9th June 2025

RE: Doncaster Road, Darfield - Ref 2024/0580

Taking each of the consultation comments provided in turn, I can advise the following:

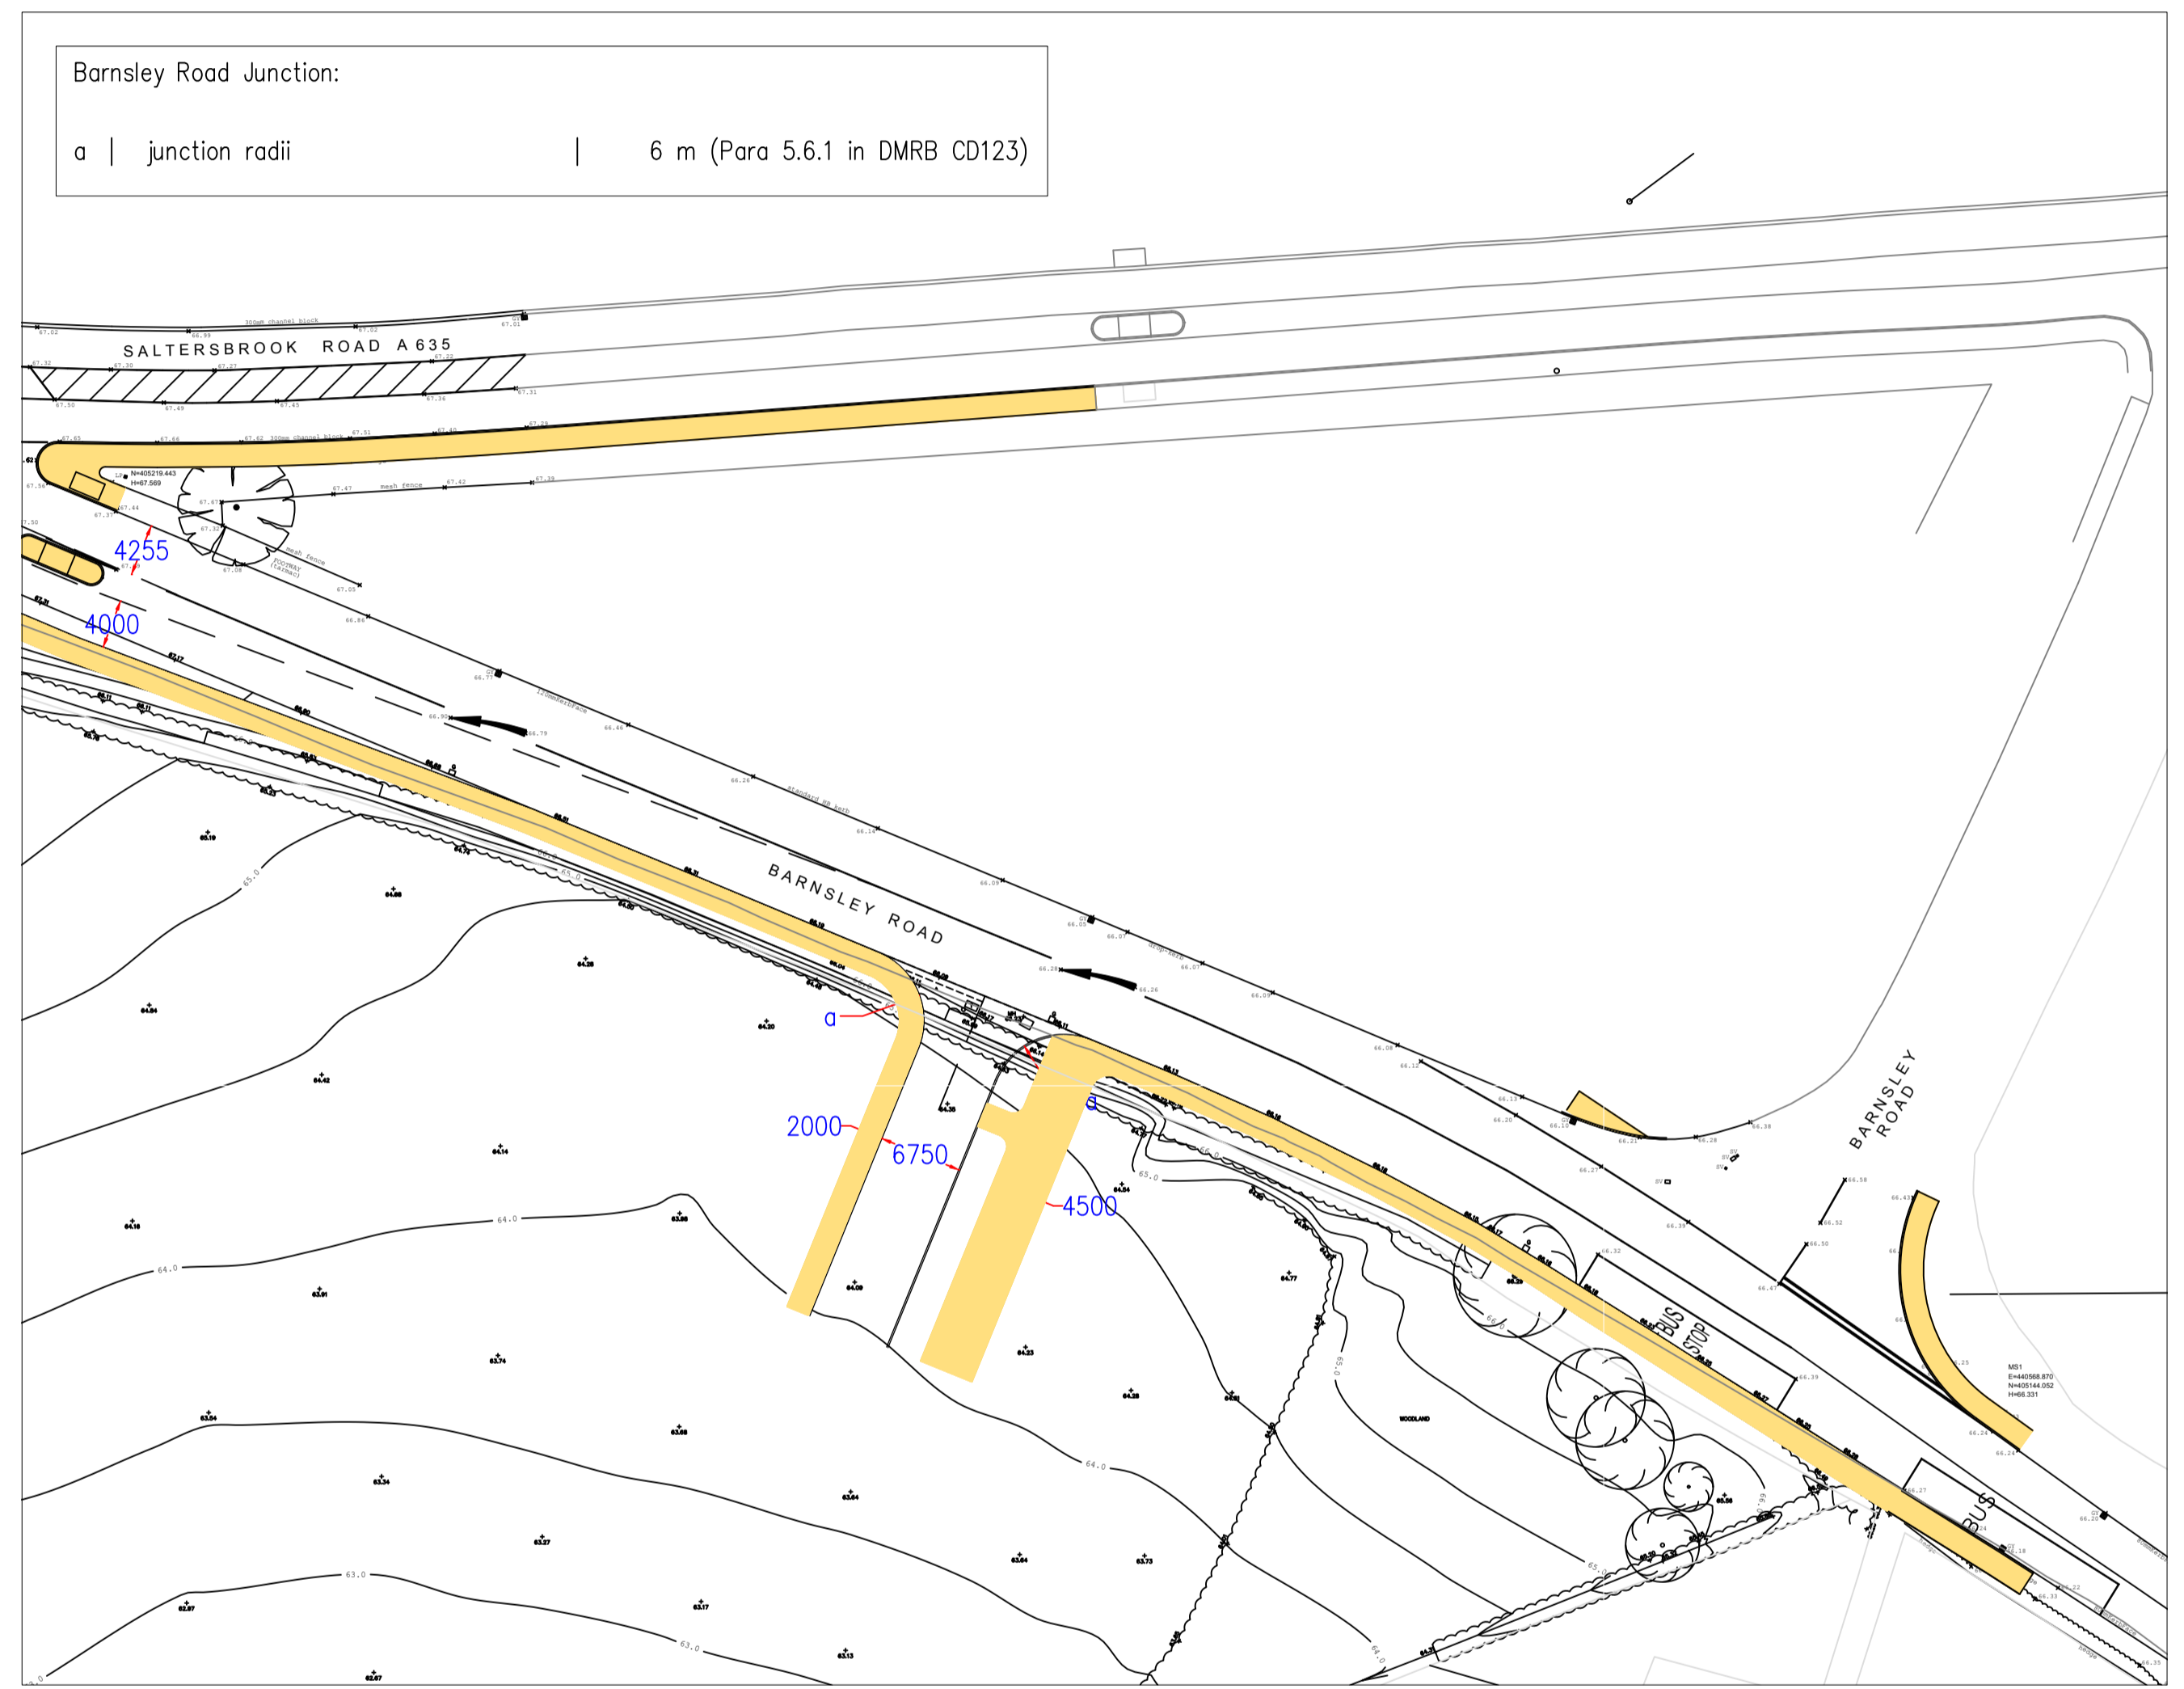
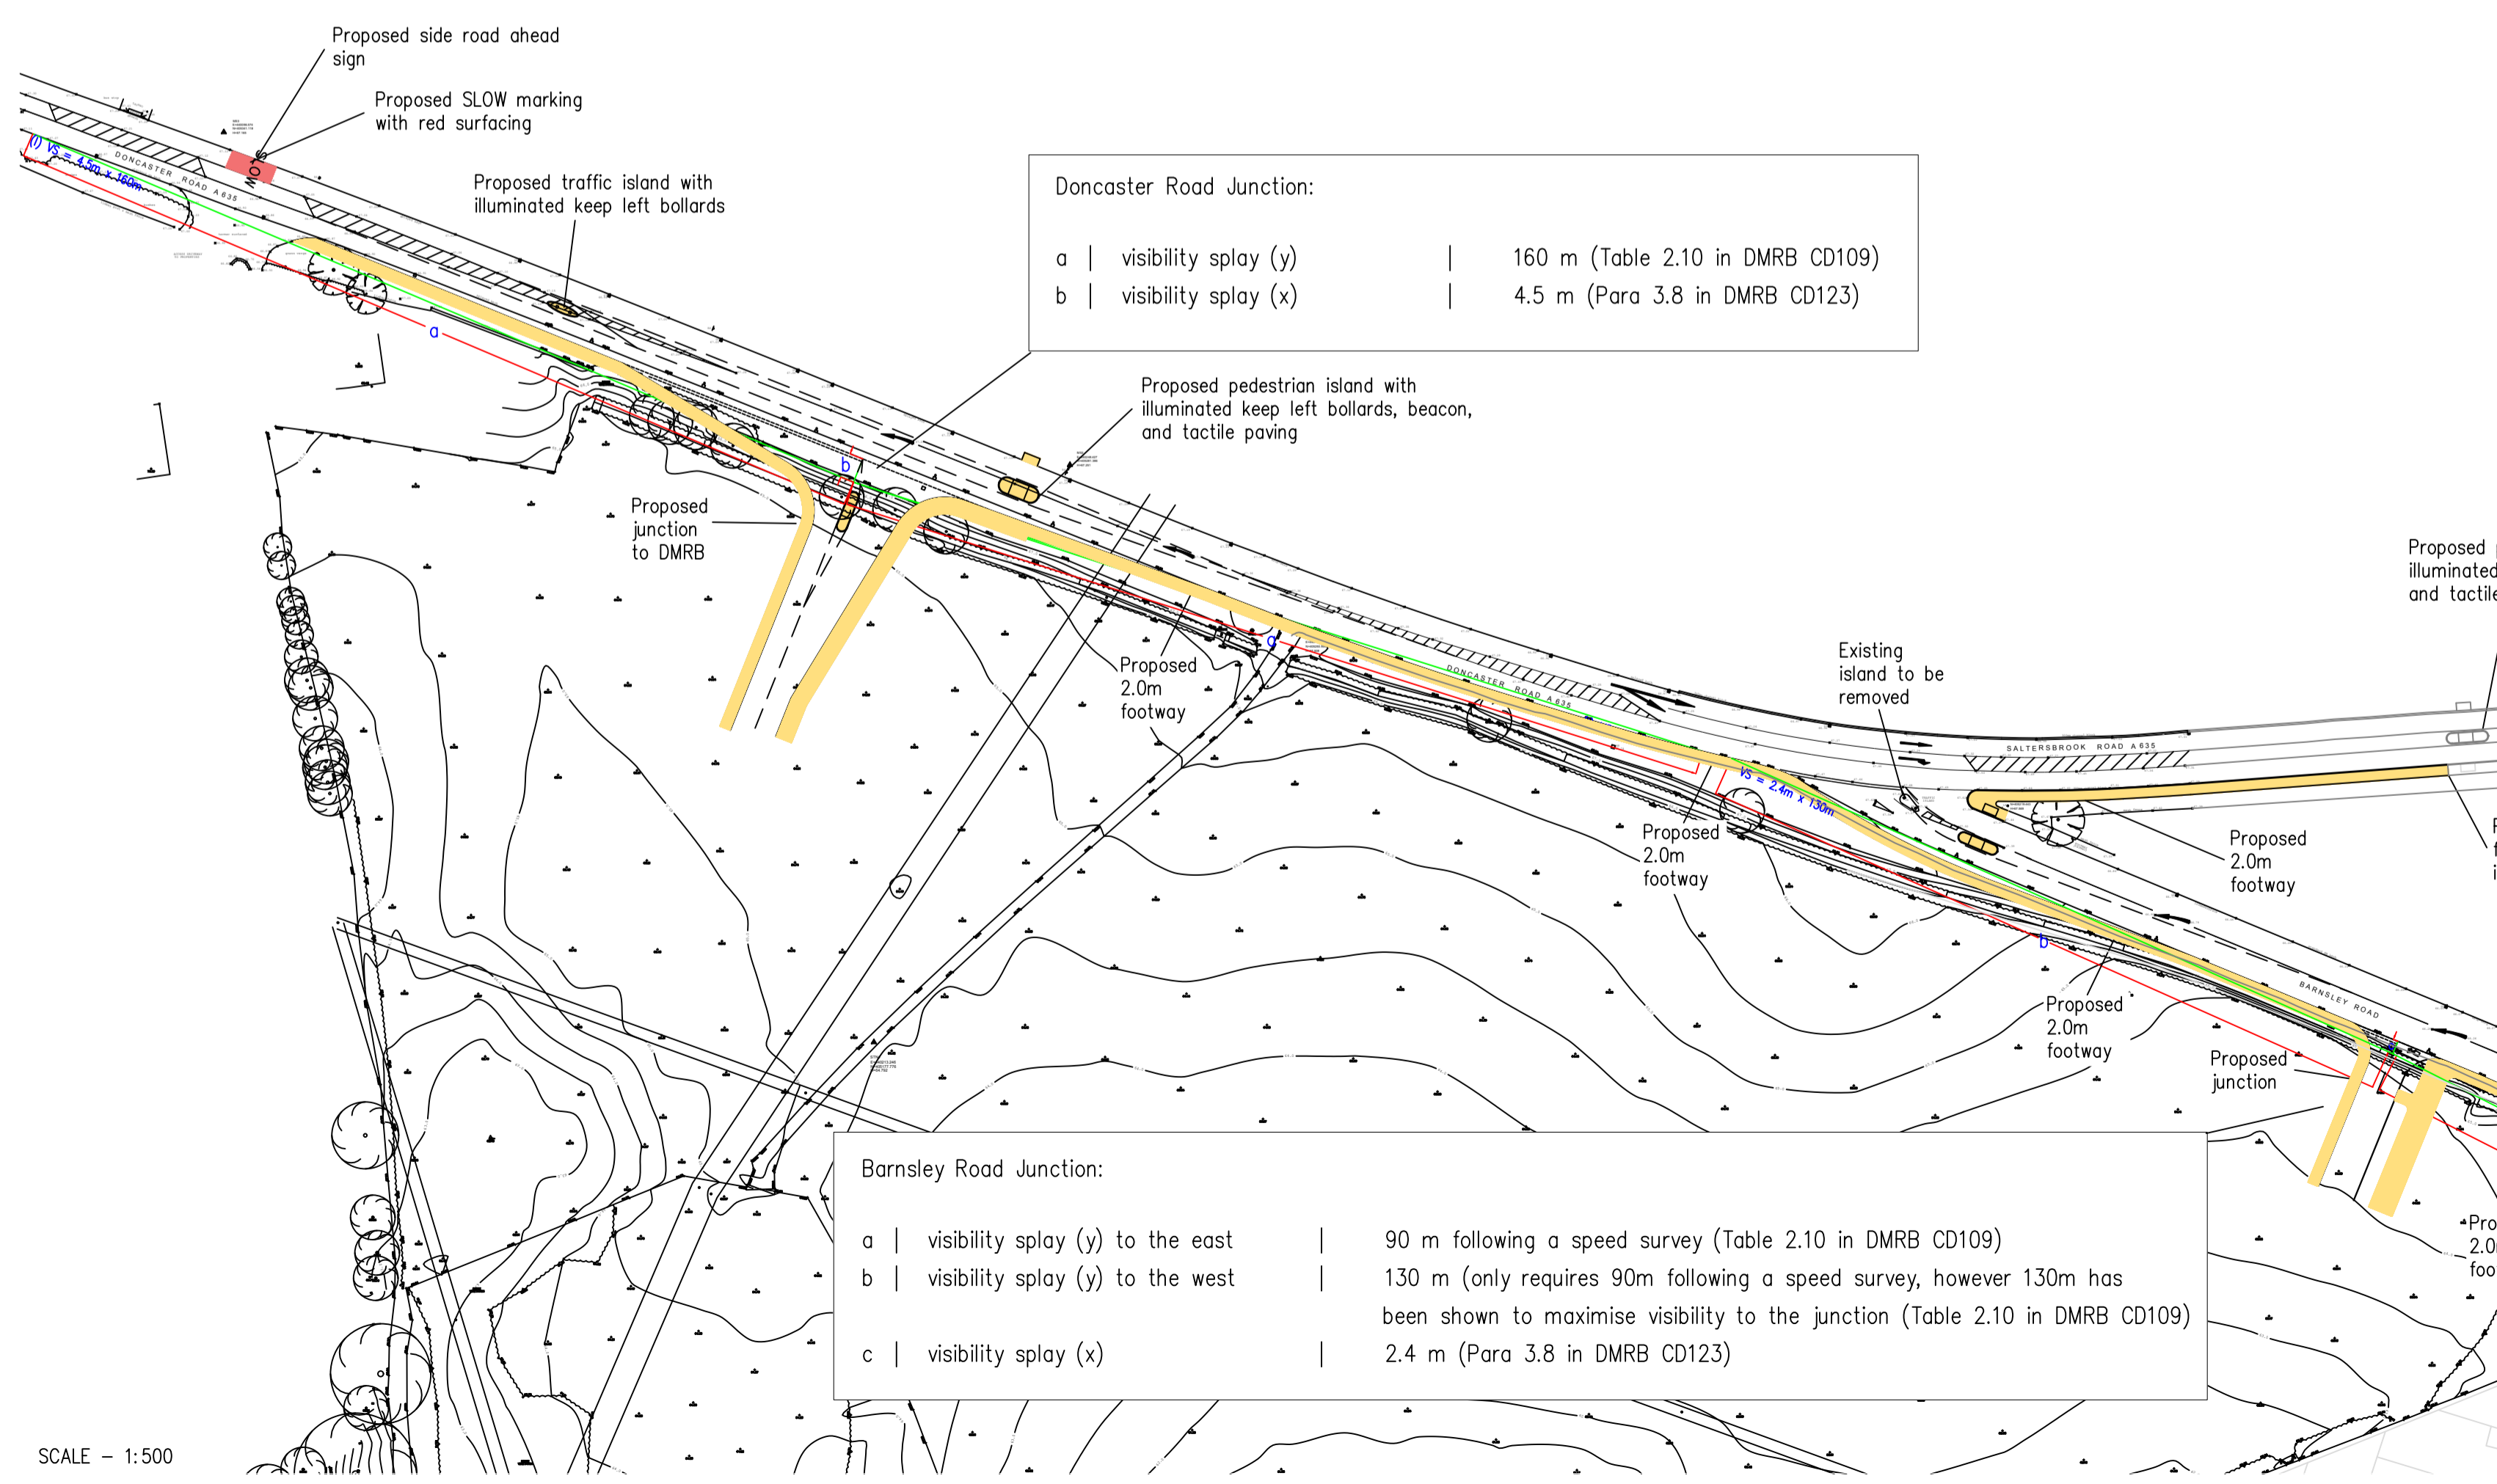
The site access shows the 2m footway on the western side continuing along the radii on to Doncaster Road however, there is no continuation of footway on this side. The footway should terminate at the tactile paving to prevent pedestrians from walking along this section which will stop with no means to cross on to the opposite side of the carriageway.

The layout has now been revised to identify the latest access designs for the site in line with the comments provided. This has been designed in conjunction with the latest transport work completed by PAH Highways.
